Recommendation Report for Planning Permission

REF NO: BR/204/17/PL

LOCATION: 23 Station Road
Bognor Regis

PROPOSAL: Re-construct shop-front following fire-damage to restaurant. This application affects the character & appearance of the Bognor Regis (Railway Station) Conservation Area

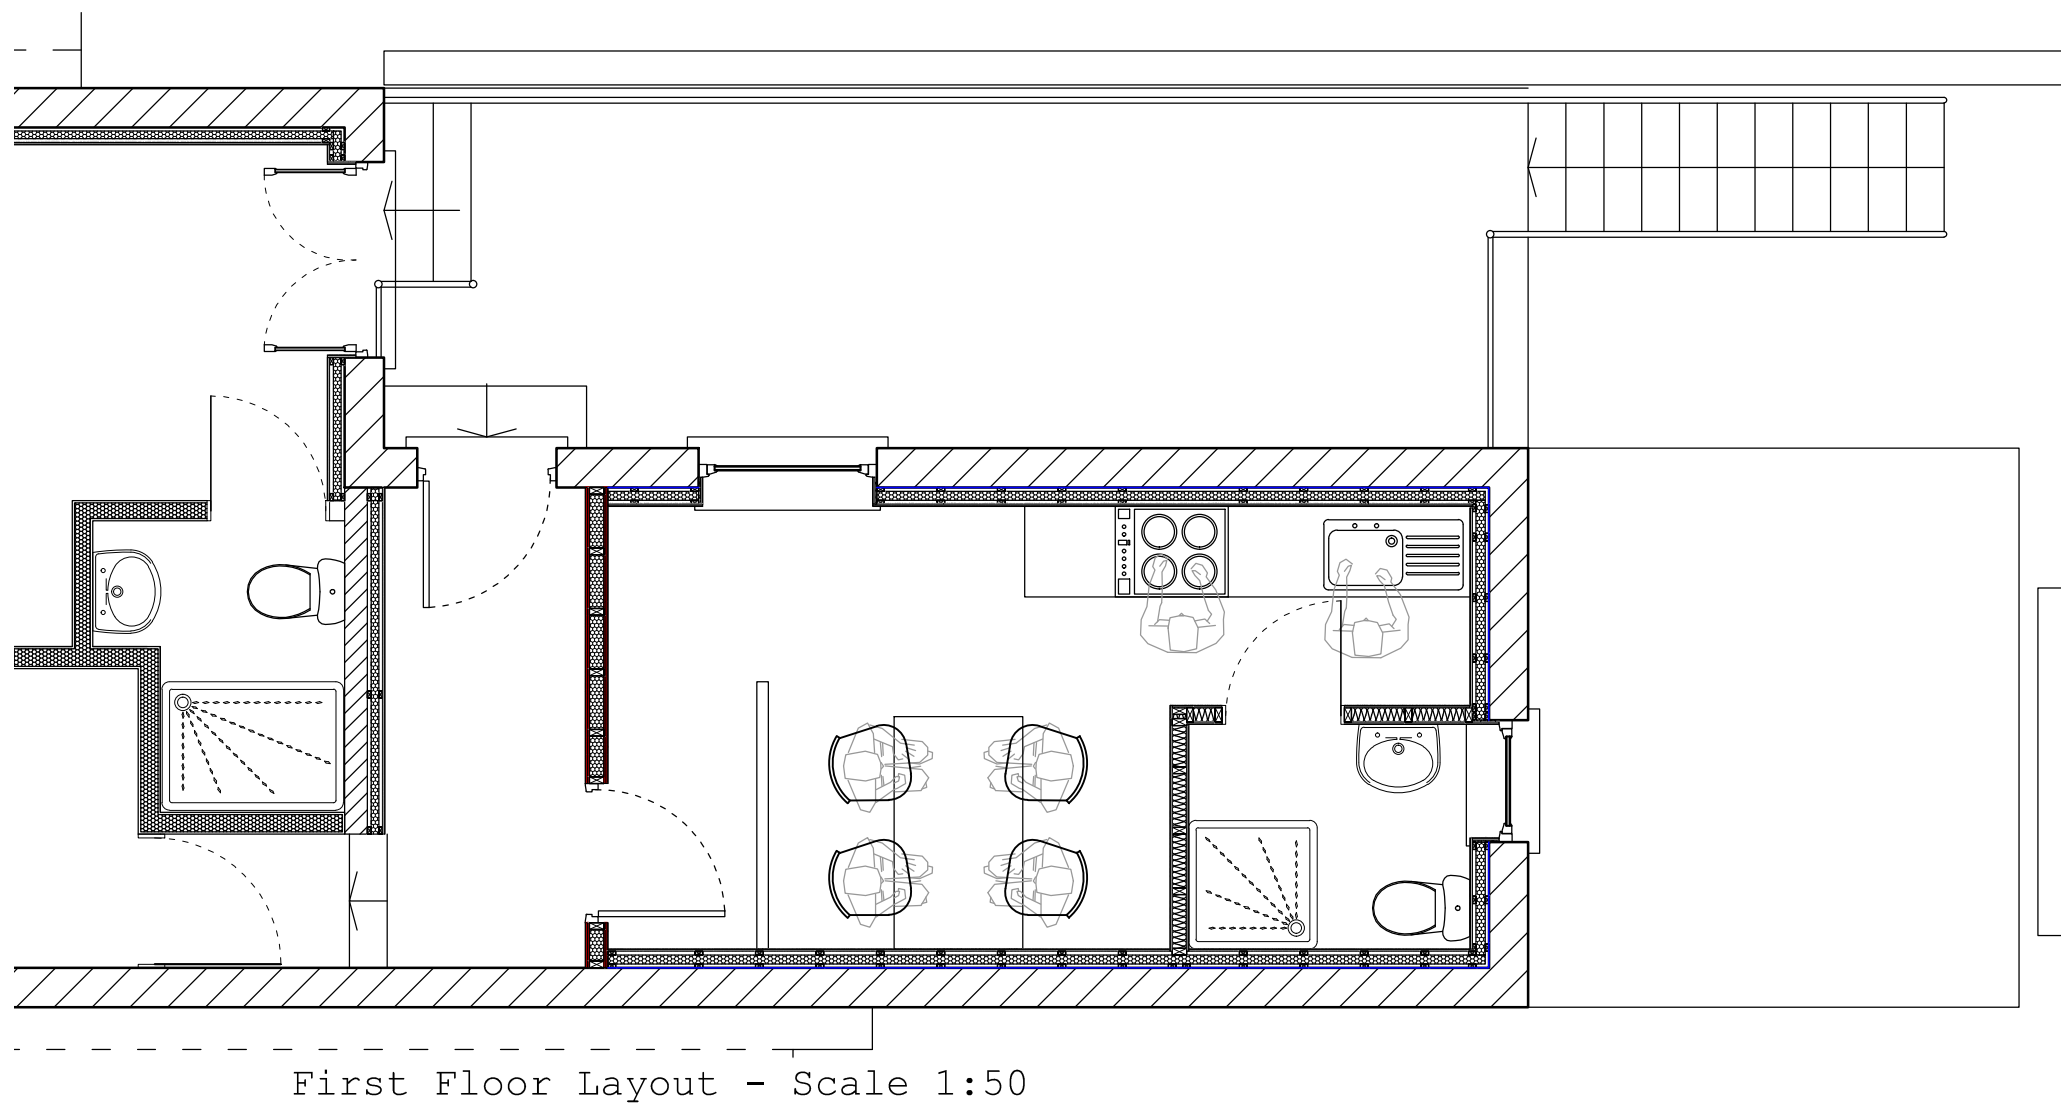
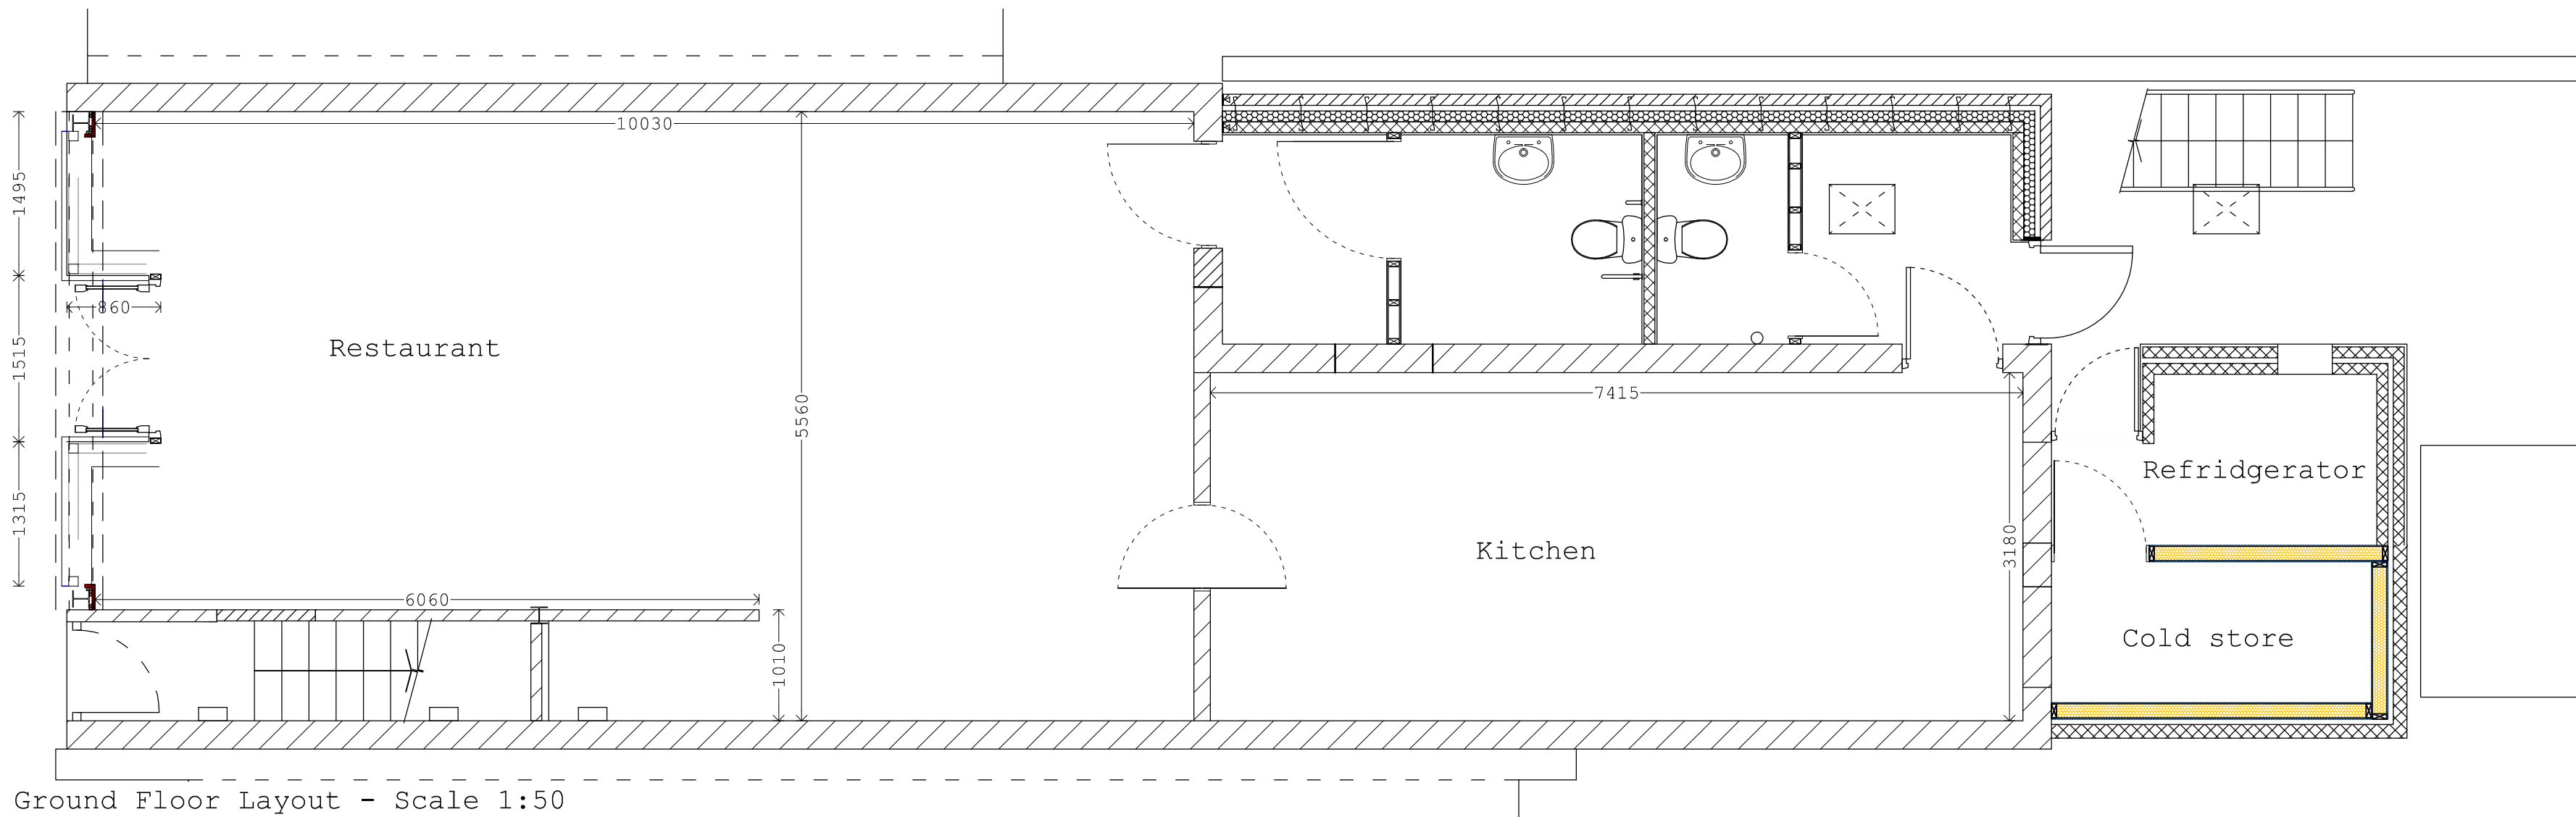
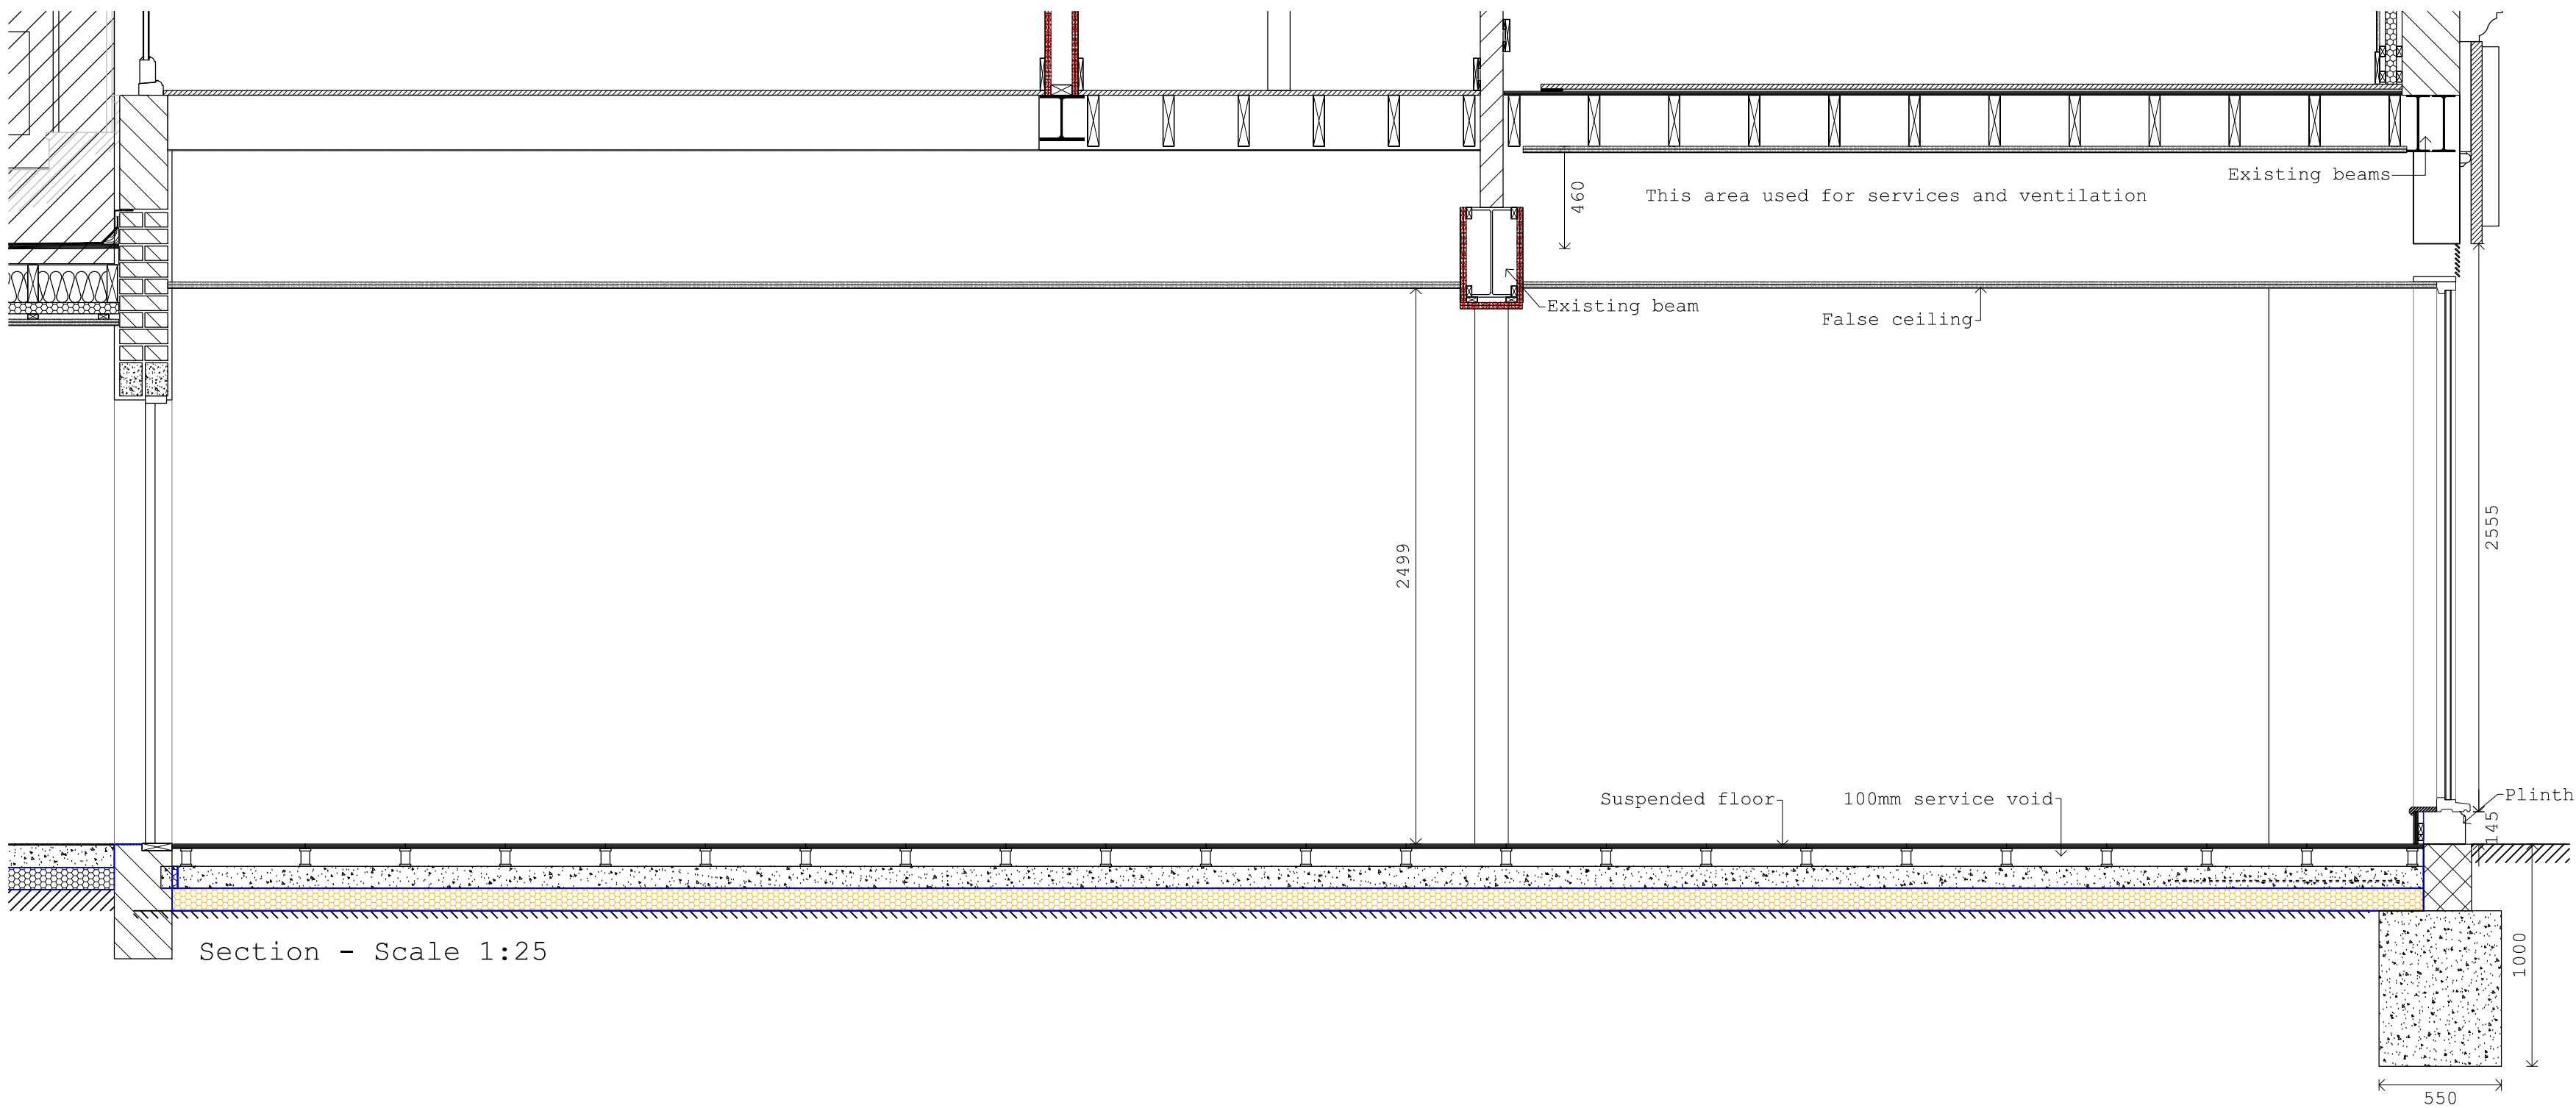
However, while details of the new shopfront have been provided, no details of the shopfront as previously existing have been submitted. Due to lack of adequate supporting documentation, it is not possible to establish whether the new shopfront is a comparable replacement, and a conclusive recommendation cannot be made in terms of Local Plan 2003 Policy Area 2 and Local Plan 2014 Policy HER DM3.

The proposed shopfront represents an improvement to the appearance of the premises and therefore the setting of the nearby Conservation Area and Listed Building. The previous shopfront was 'tired' and unappealing. The upgrade to the appearance of the premises makes a positive contribution and enhances to setting of the nearby Conservation Area and Listed Building. The proposal is therefore considered to be in accord with both local and national policy and guidance.
